Our Ref: F/9/19/PL
Your Ref:

Town & Country Planning Act 1990 (as amended)
Town and Country Planning (Development Management Procedure) (England) Order 2015
Application for Planning Permission

Development Change the use of 1/2 the site area to a hard standing storage area
Location Land Adjacent Station Cottages Ford Road Ford

LOCATION PLAN -

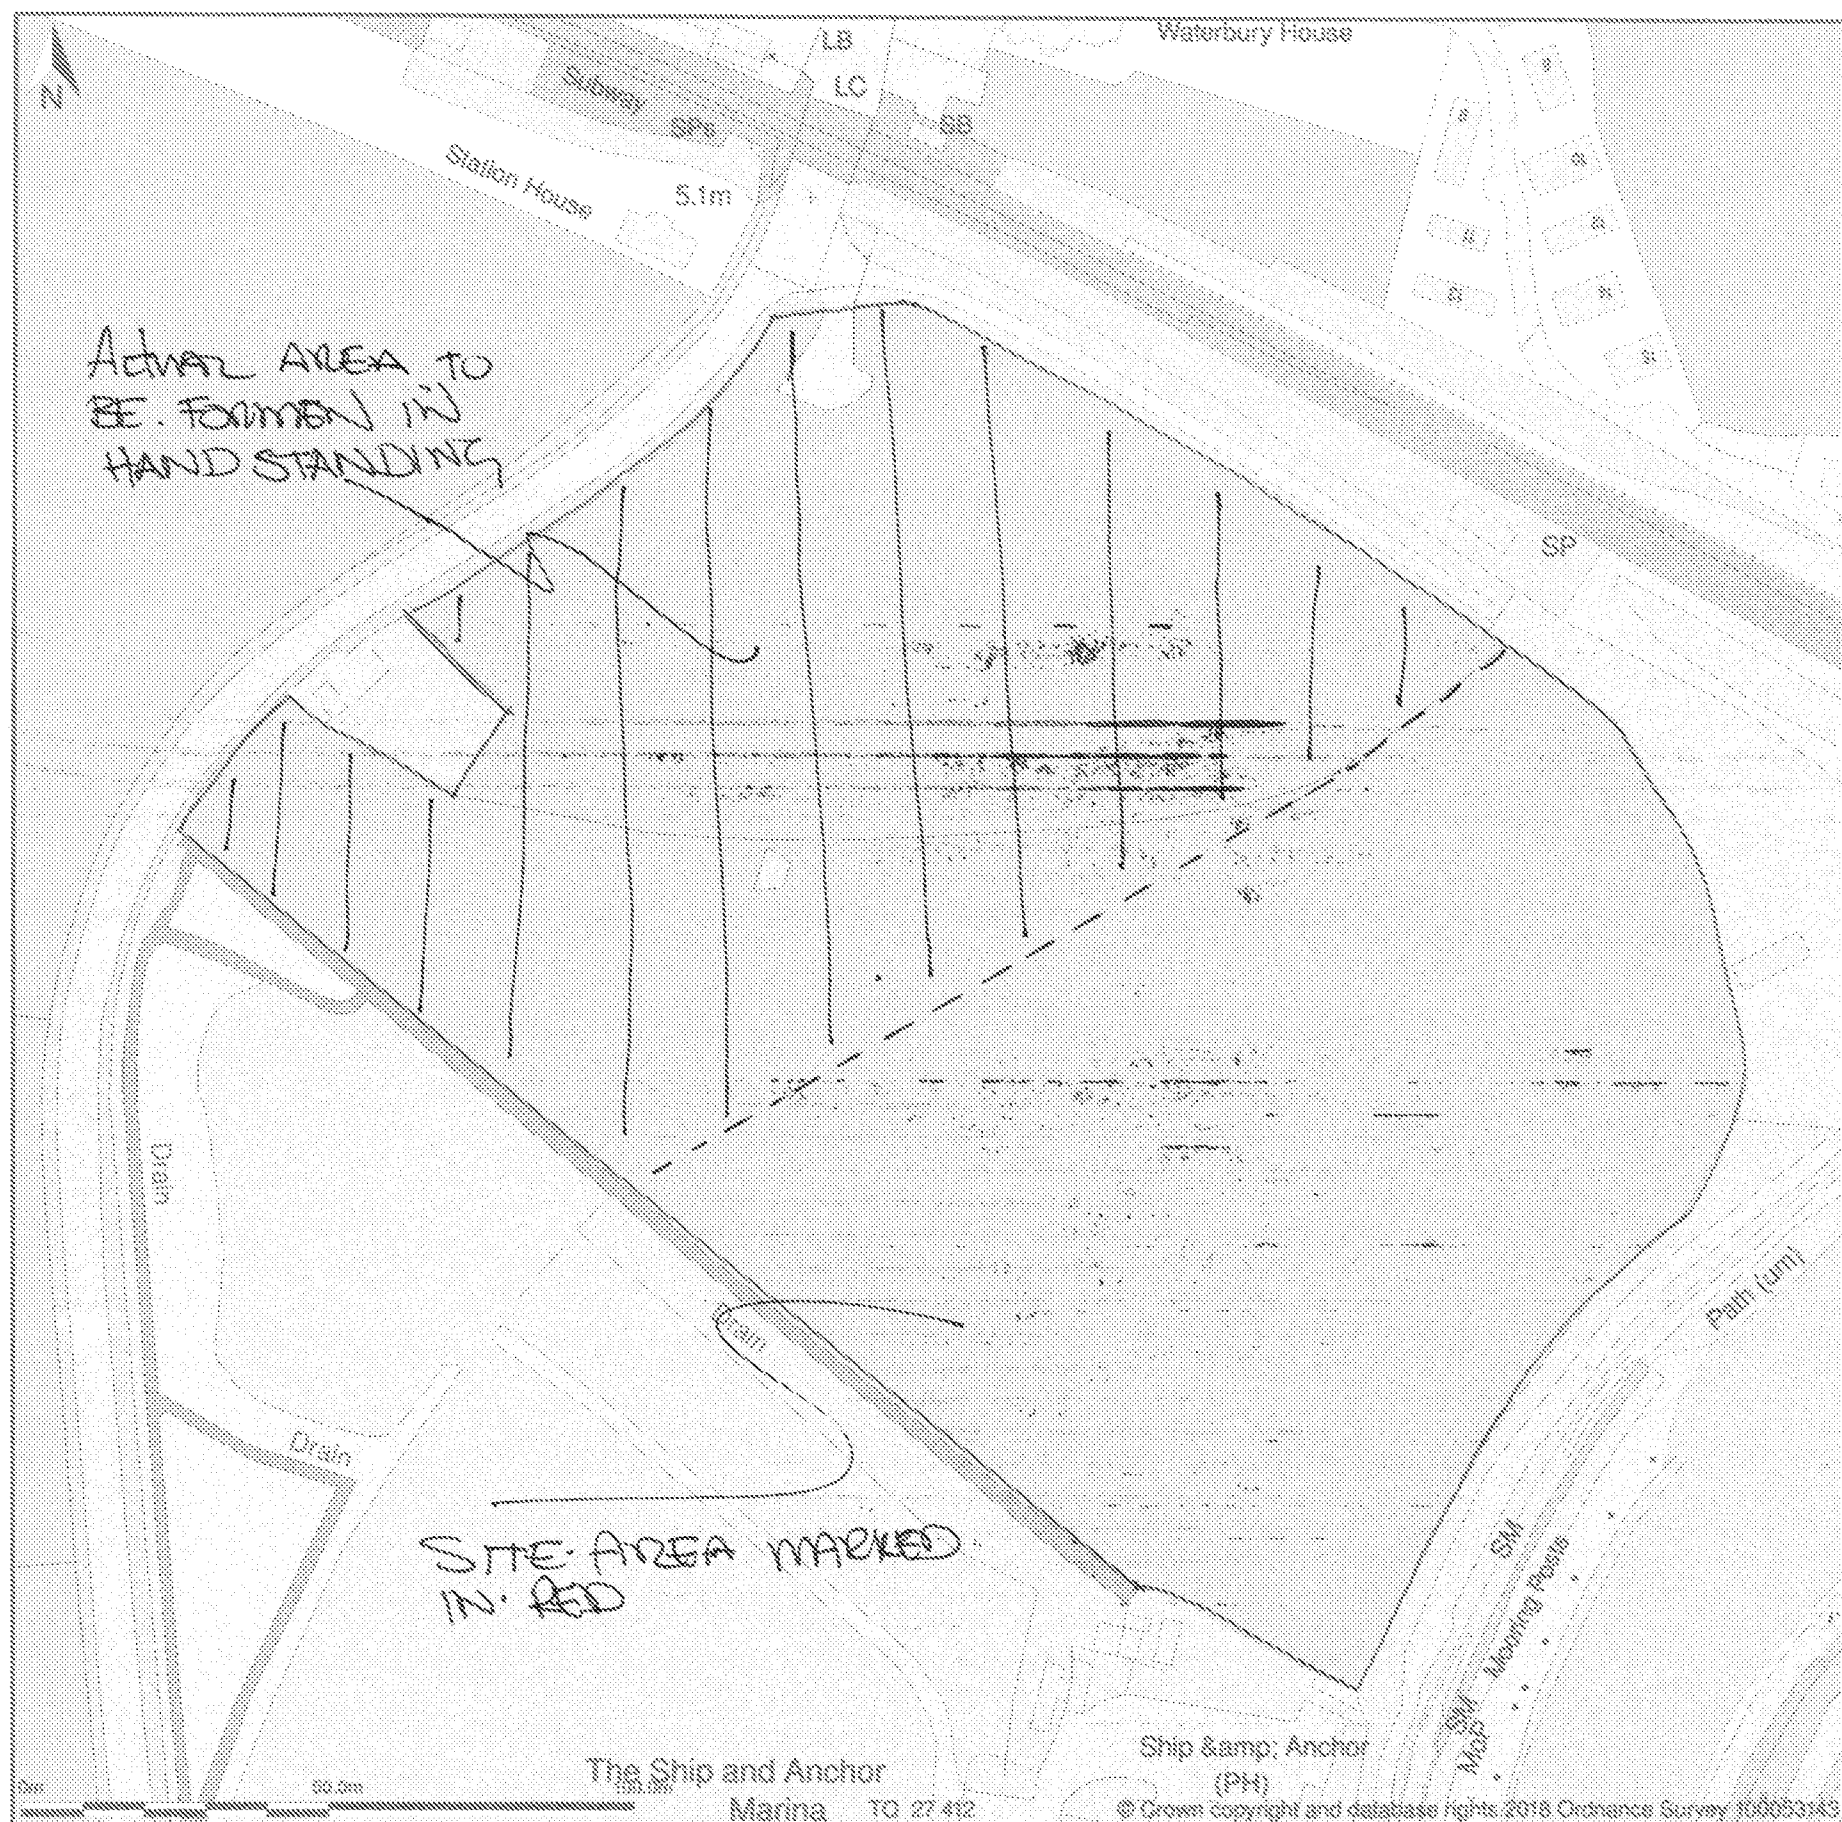
Location Plan Amend

Please red edge the application site and blue edge any adjoining land that is in the control/owned by the applicant and provide one named road.

Block Plan shows area bounded by: 500225.07, 104198.15 500277.07, 104250.15 (at a scale of 1:200), OSGridRef: TQ 25 422. The representation of a road, track or path is no evidence of a right of way. The representation of features as lines is no evidence of a property boundary.

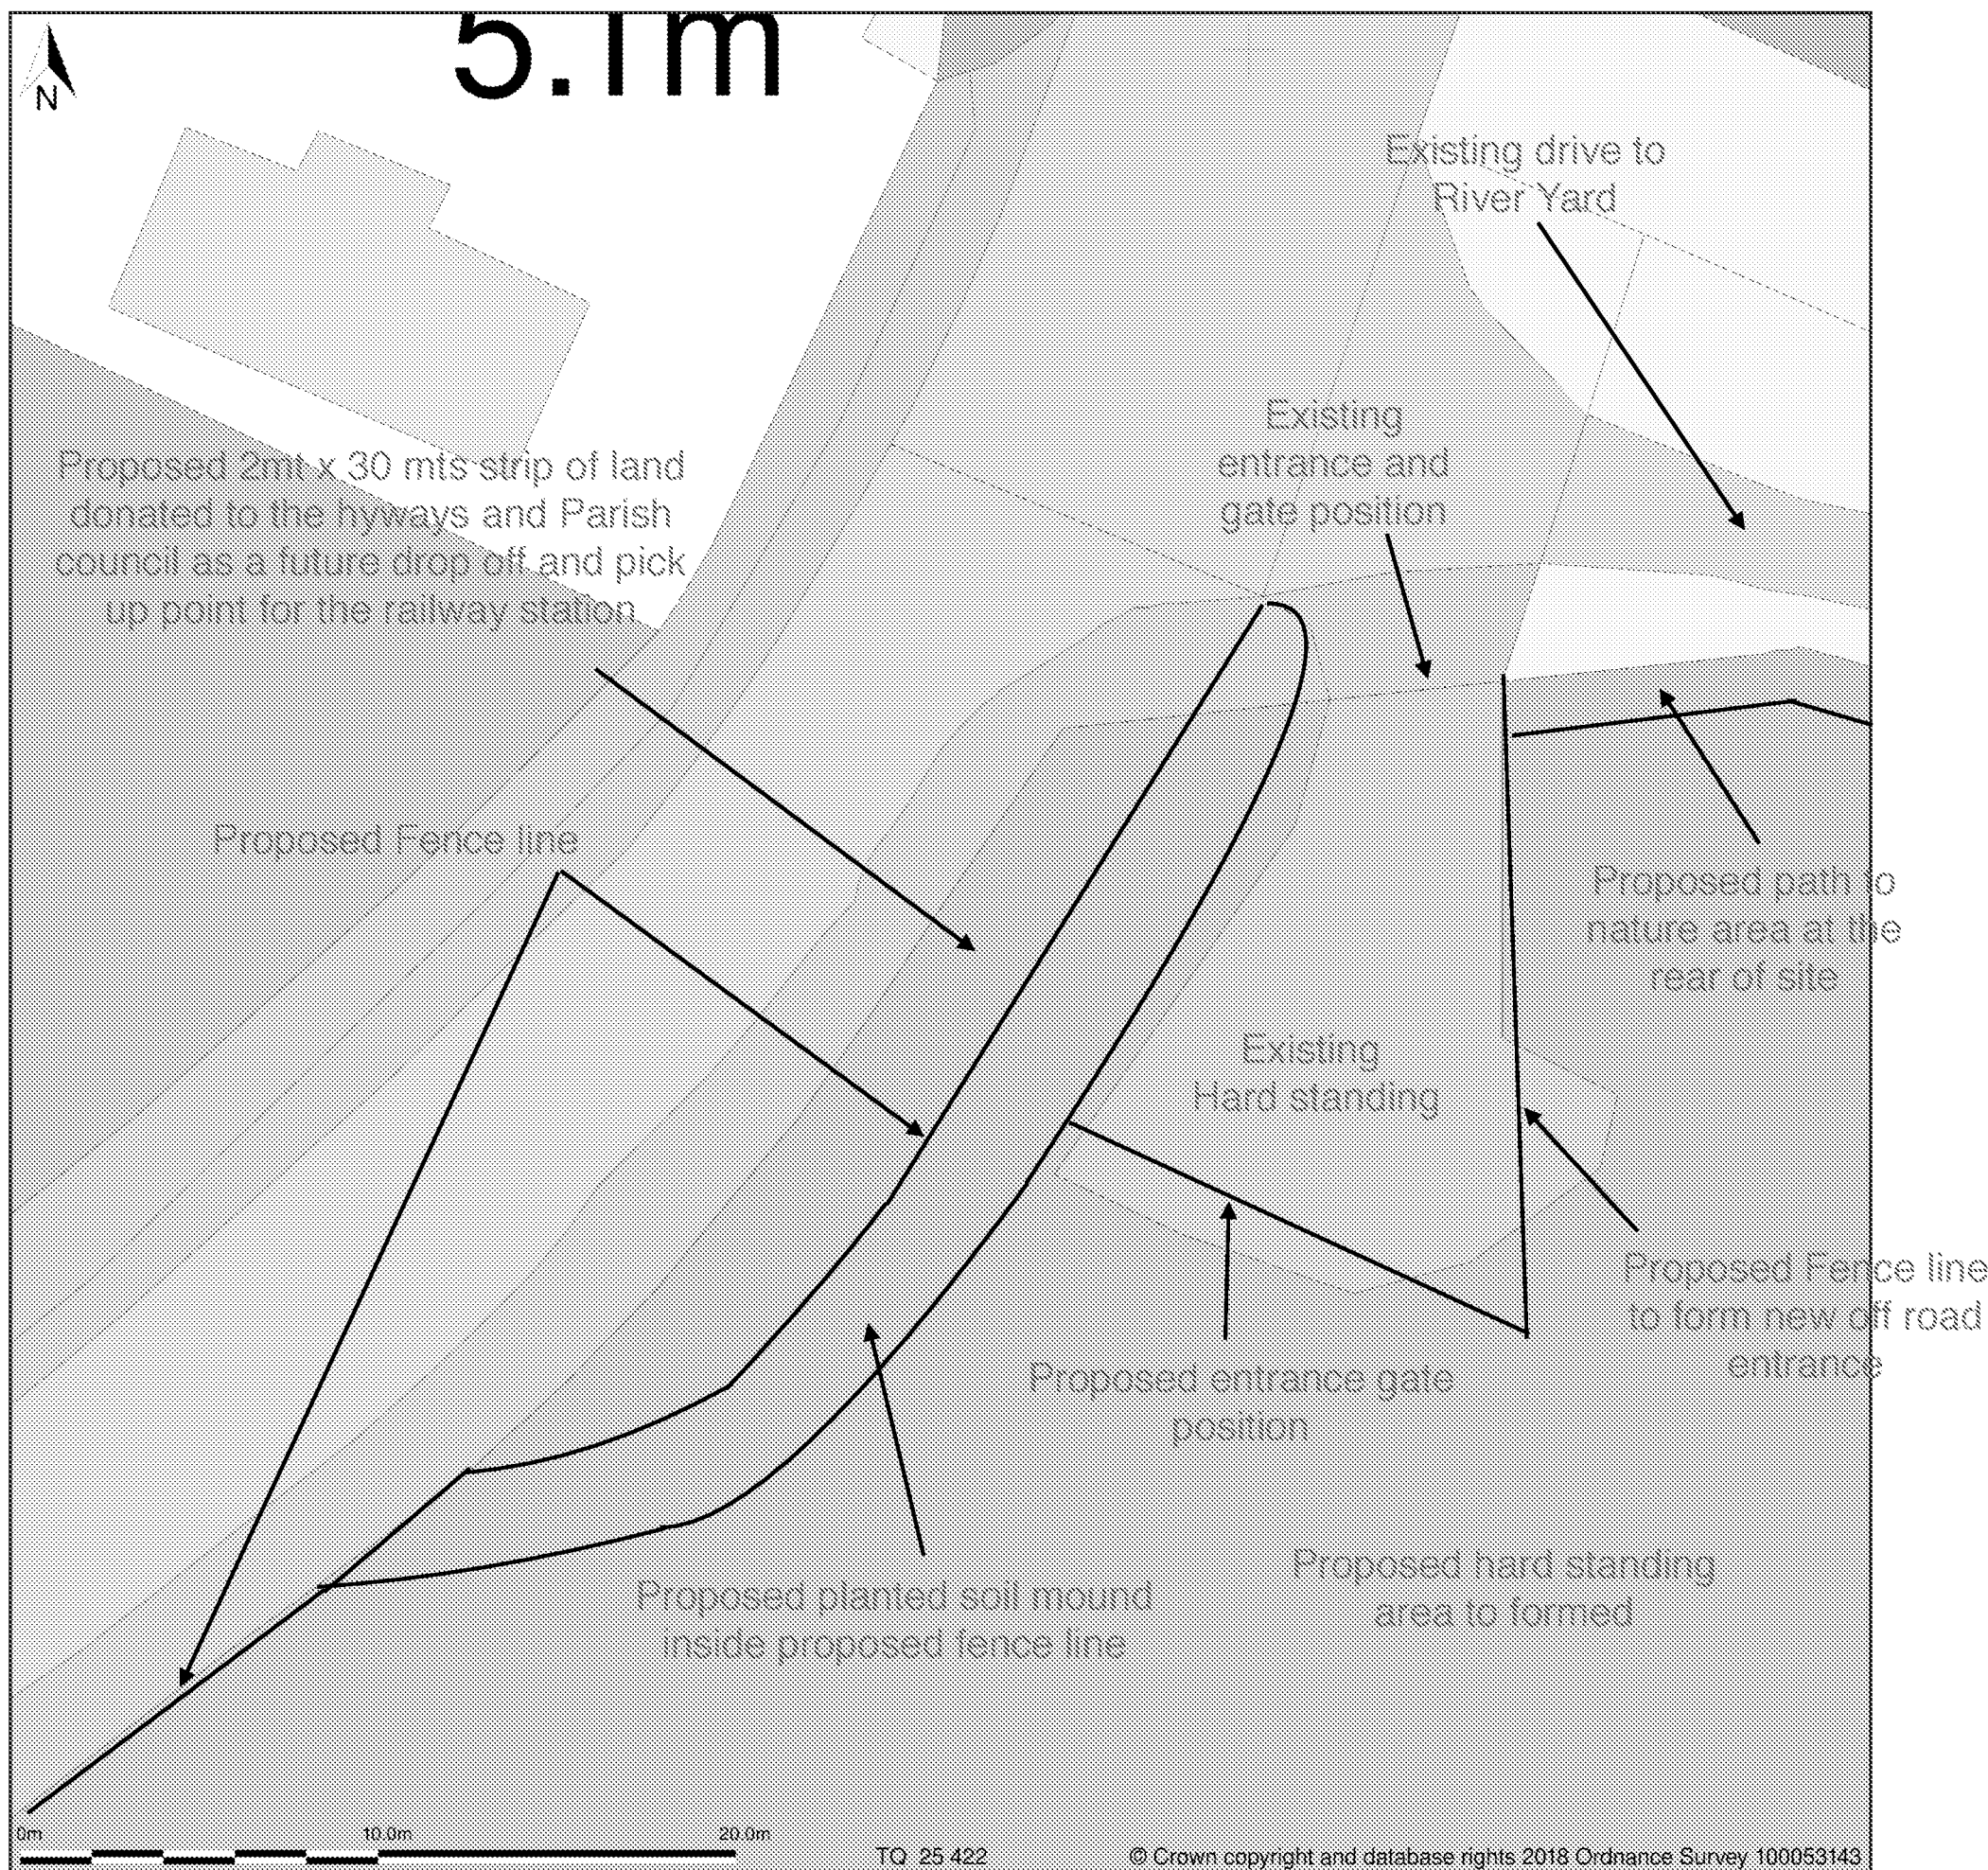
Block Plan Amend

Please provide a full block plan showing the entire application site.

Proposed Fence ans earth monud elevation

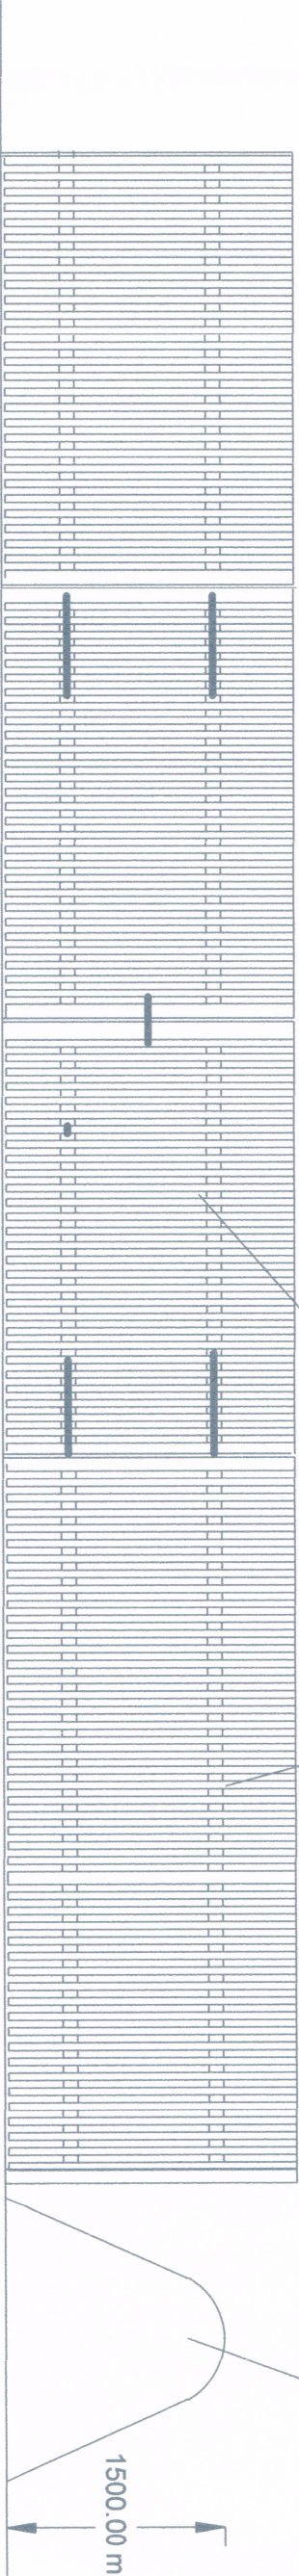
Please provide an elevation of the proposed fence and gate.

Please provide a section of the soil mound and provide measurements of the soil mound.
